National Infrastructure Planning  
Temple Quay House  
2 The Square  
Bristol, BS1 6PN

Our Ref: EN010106

### **Application by Sunnica Ltd for an Order Granting Development Consent for the Sunnica Energy Farm**

#### **Advice following issue of decision to accept the application for examination**

**Drawing Title**  
 FIGURE 9-1  
 SURFACE WATER BODIES  
 AND THEIR ATTRIBUTES

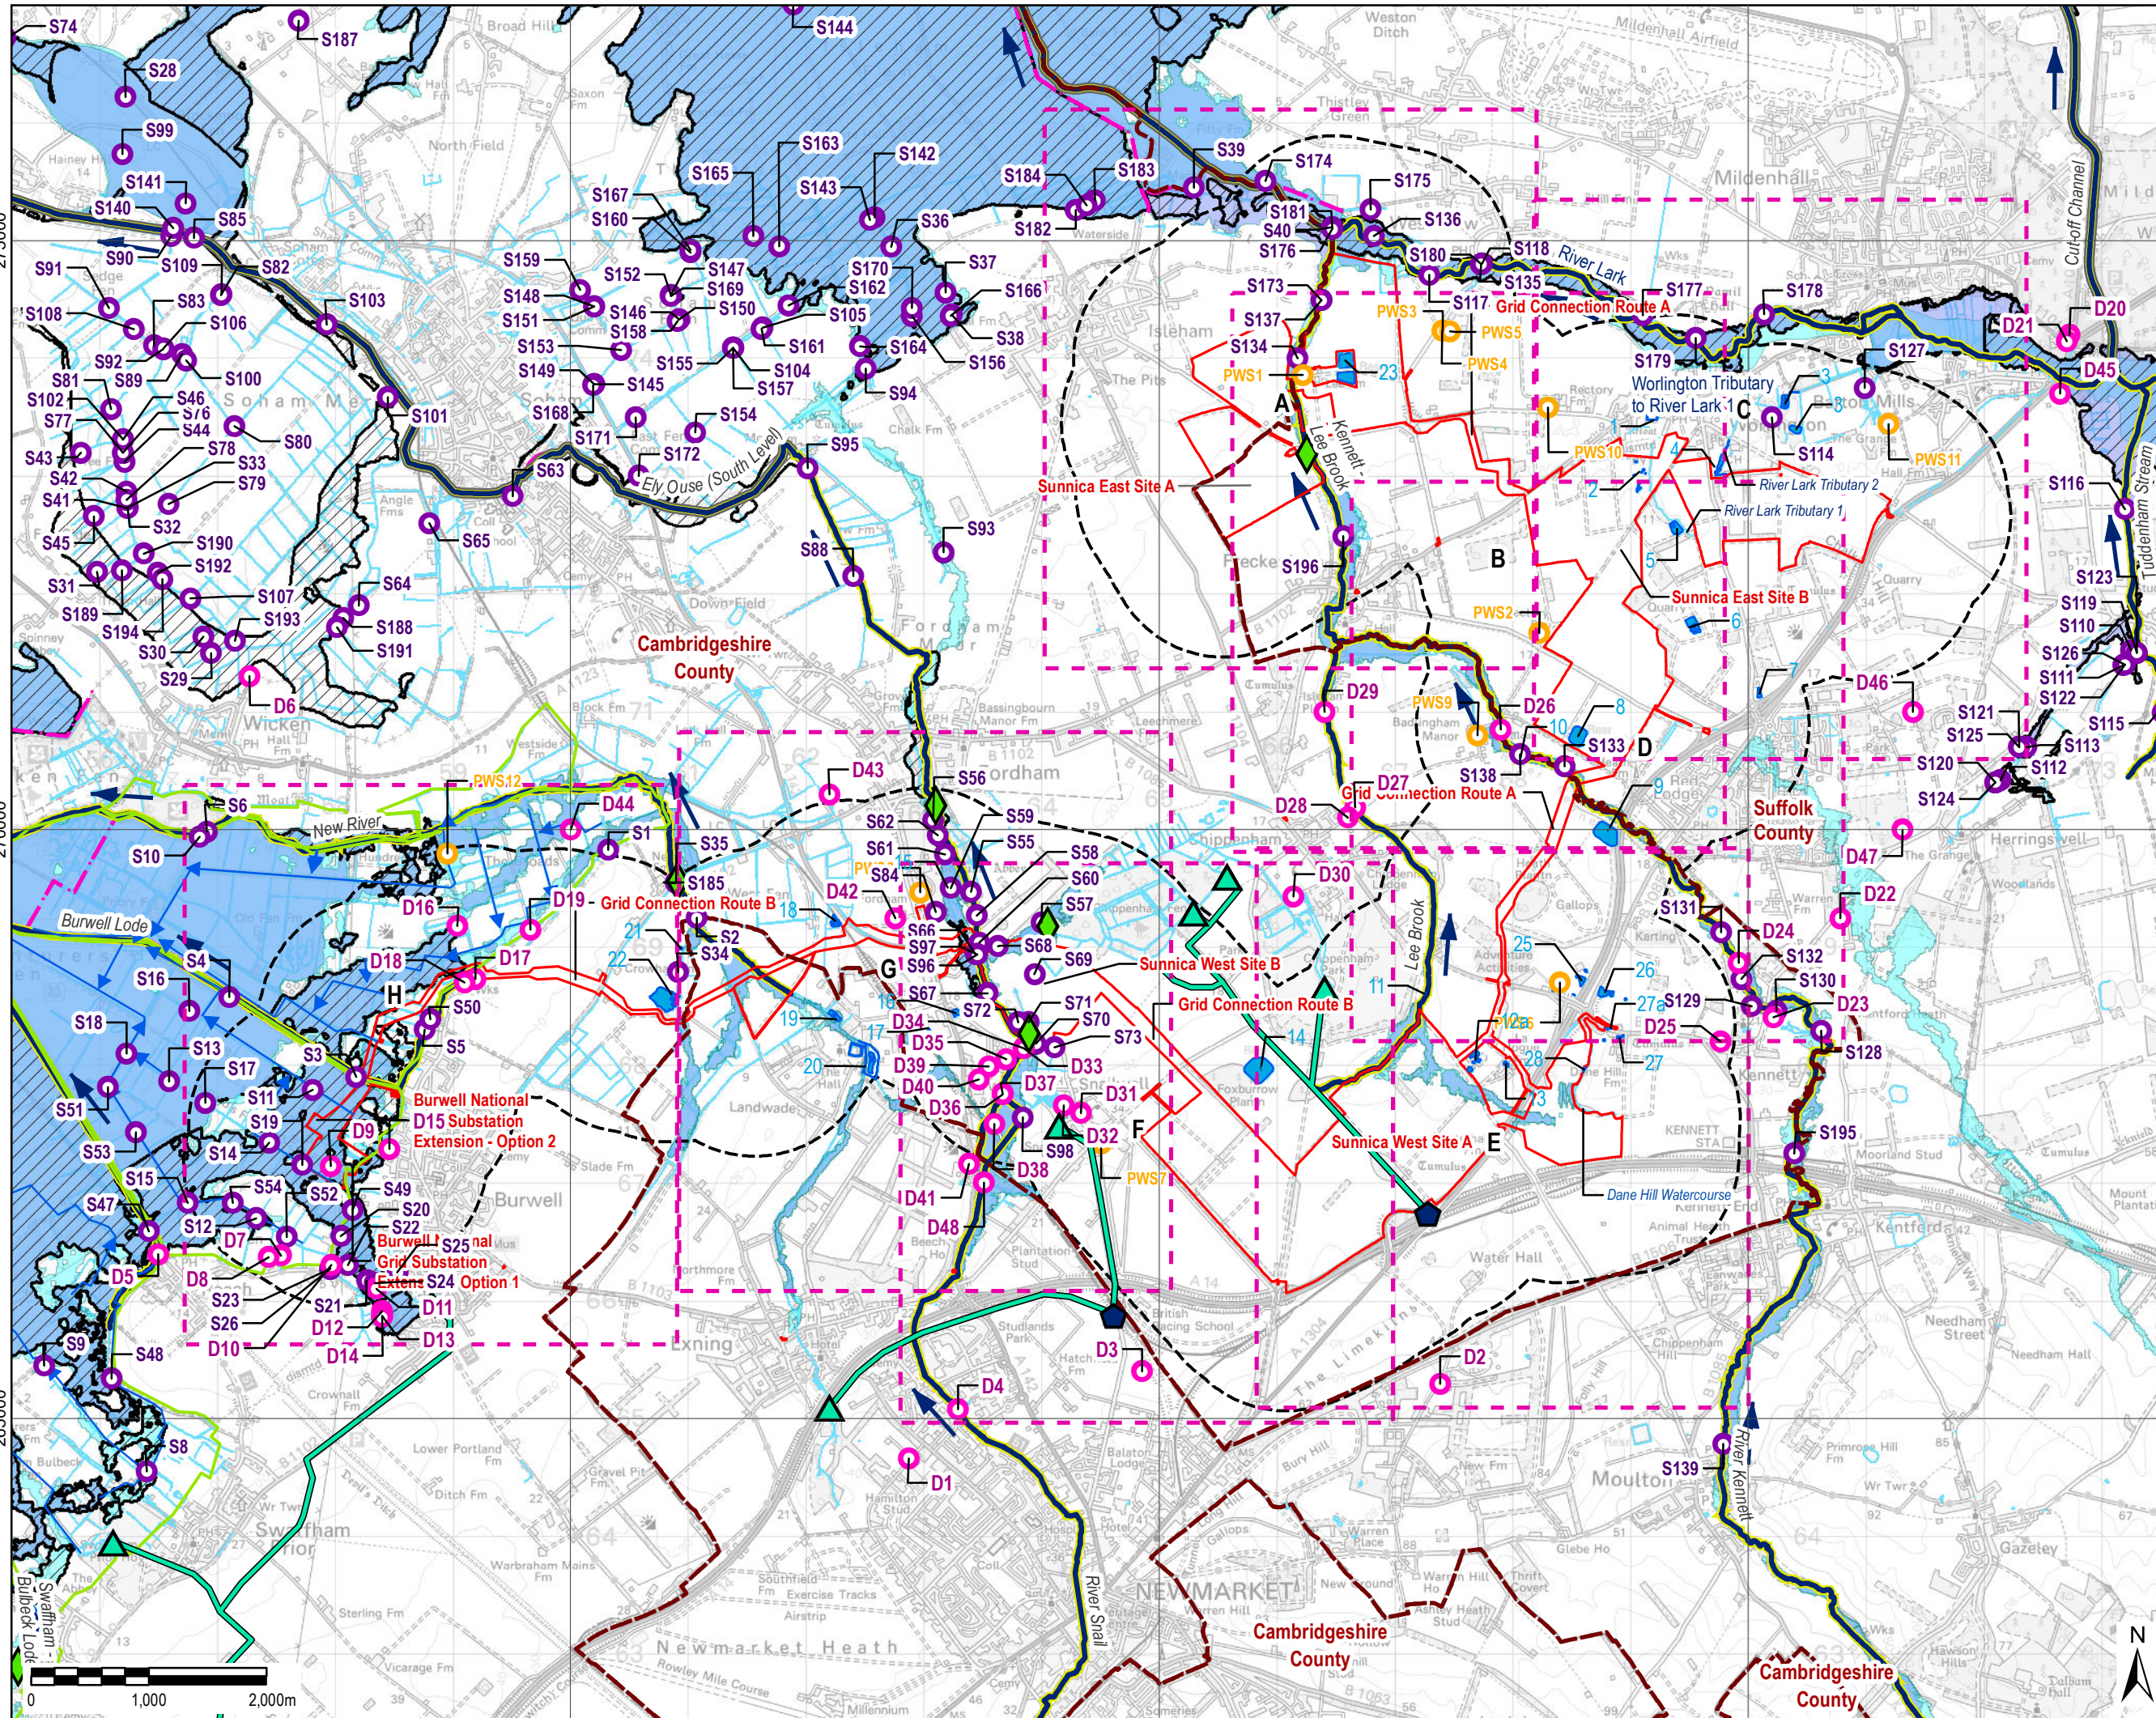
Figure 9-1 demonstrating the location of surface waterbodies contains multiple layers of information, which are presented at a resolution that hinders interpretation of the information. This information should be resubmitted in a revised format (e.g. at higher resolution in one or more plans) to enable a clear understanding of the surface water receptors that have been considered in the assessment.

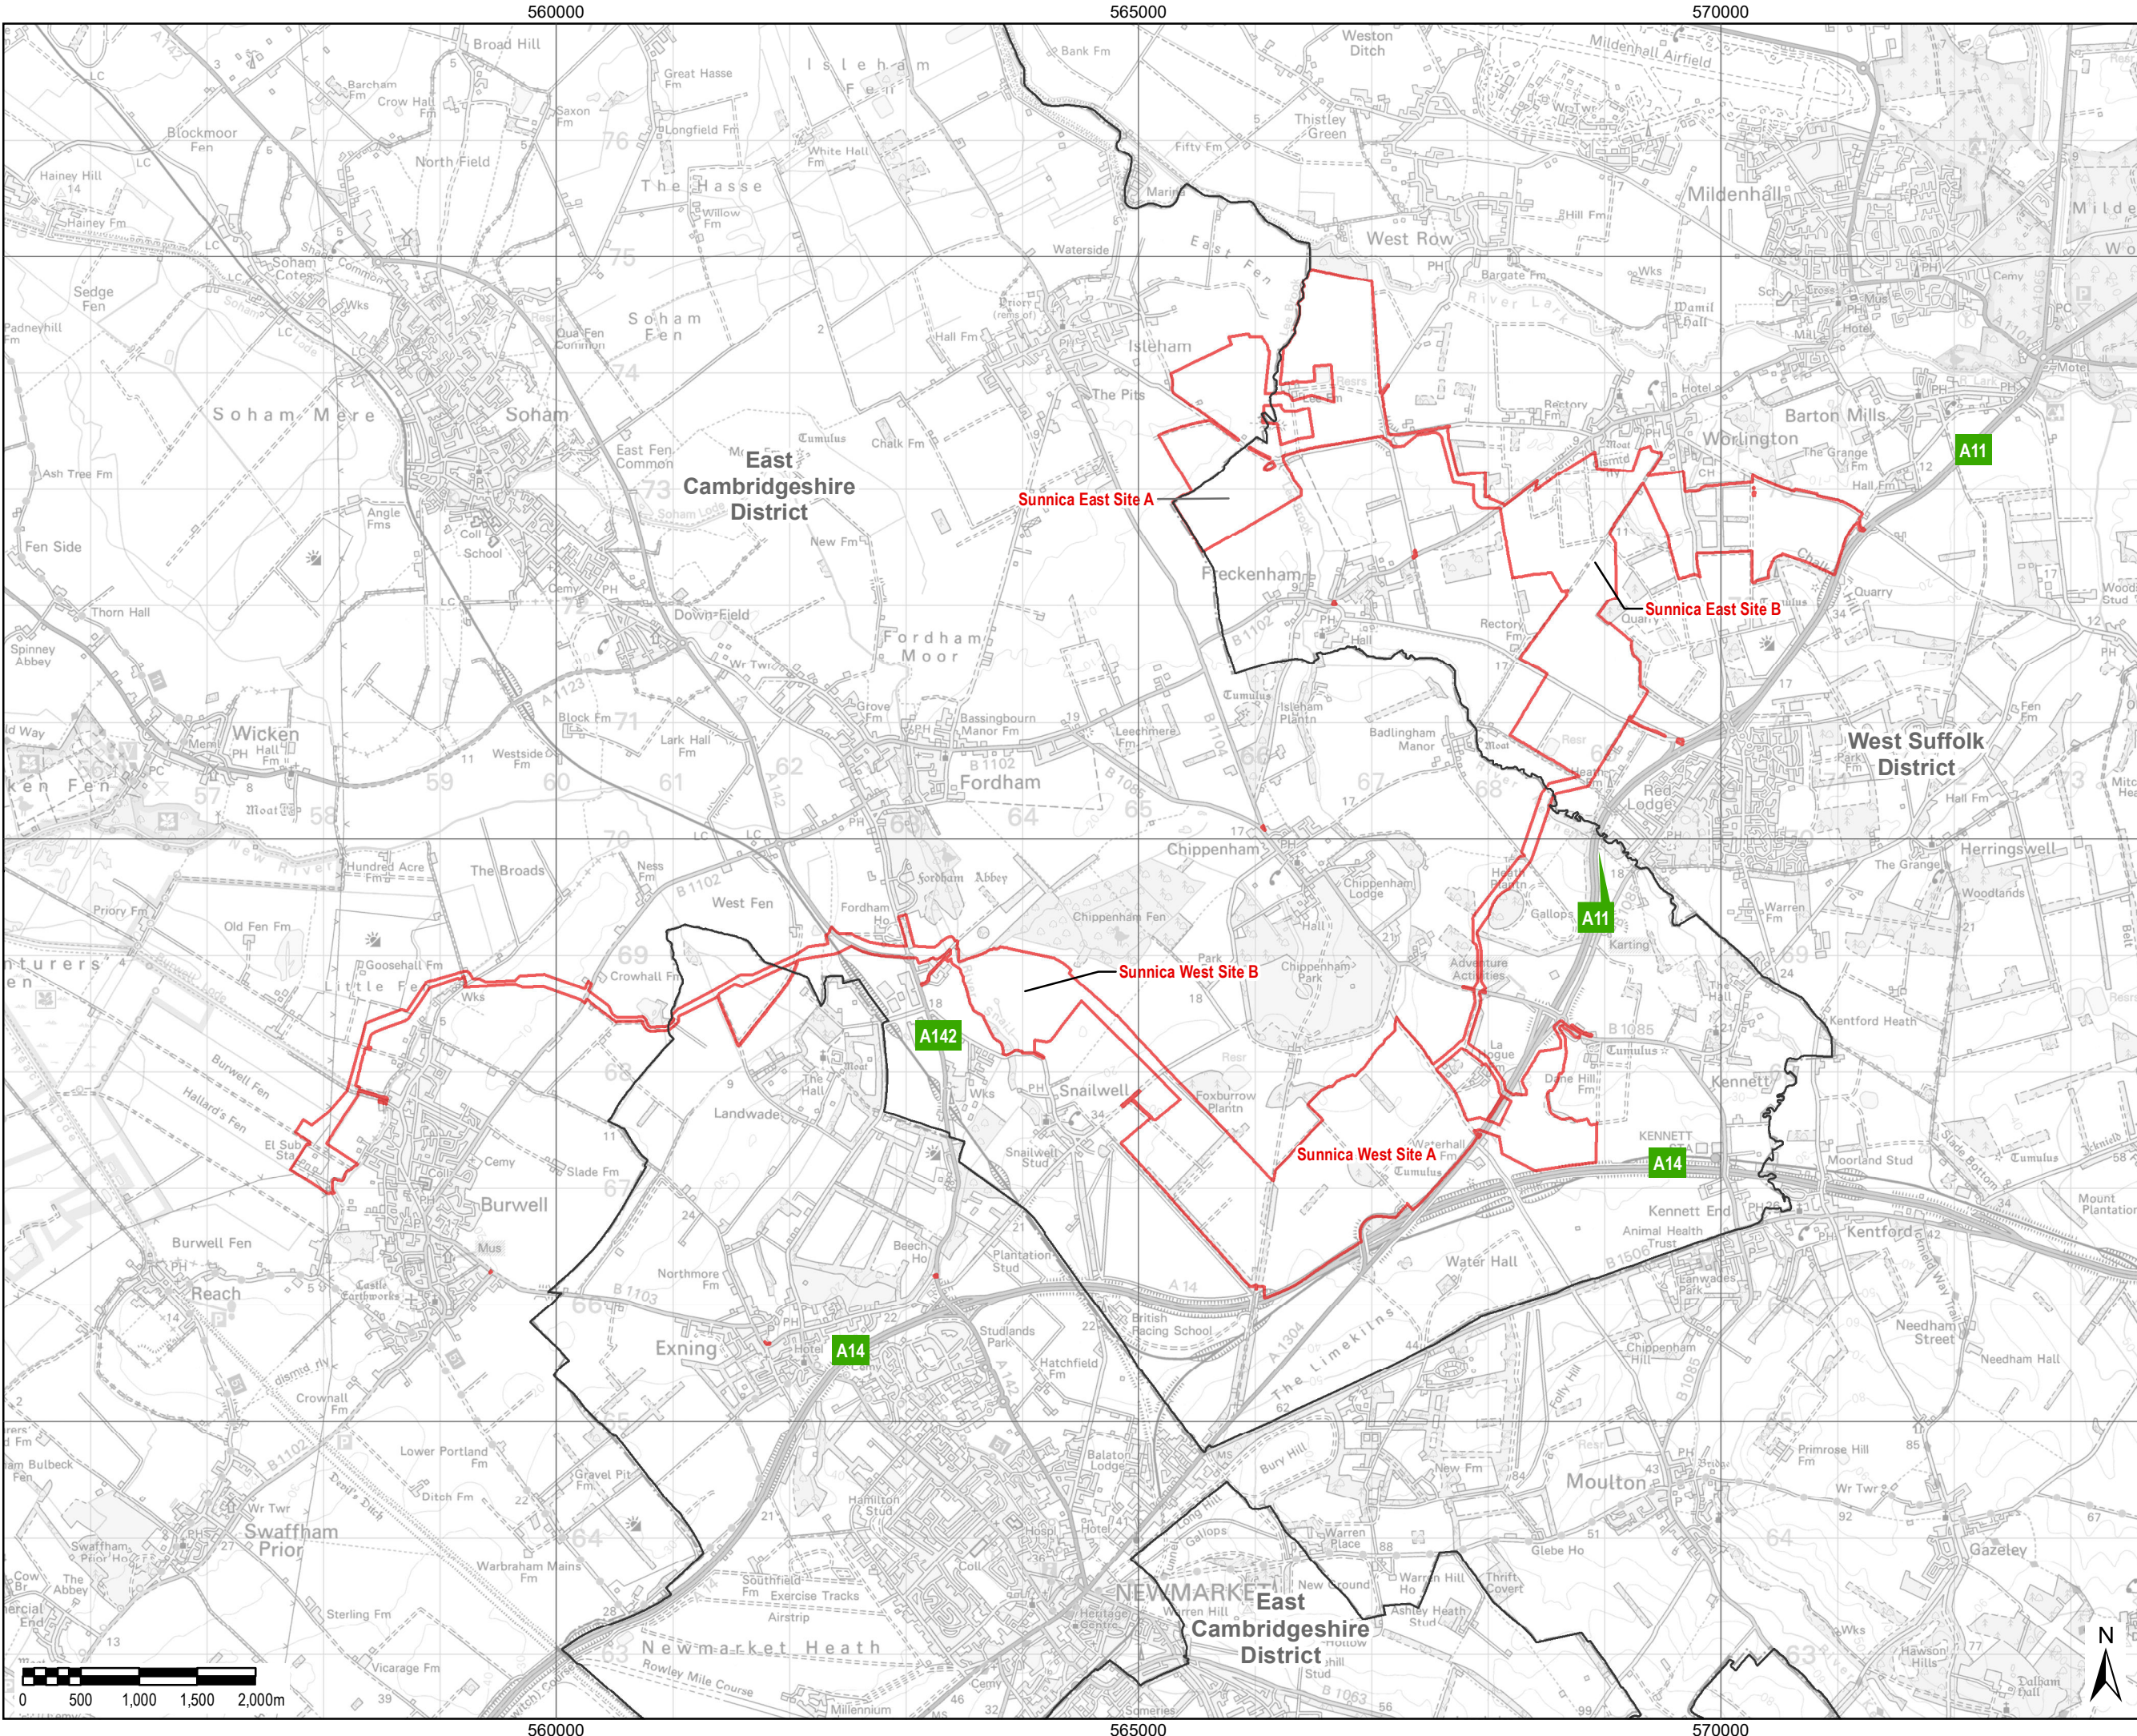
As noted in Box 26 of the section 55 Acceptance checklist the Location Plan submitted with the application does not include any marked identifiable landmarks such as road or place names. Figure 1-1 of the Environmental Statement shows the scheme location overlaid on a detailed base map. The Applicant is advised to provide this scheme location plan at a scale of 1:2500 so that the landmark details are shown on the individual sheets.
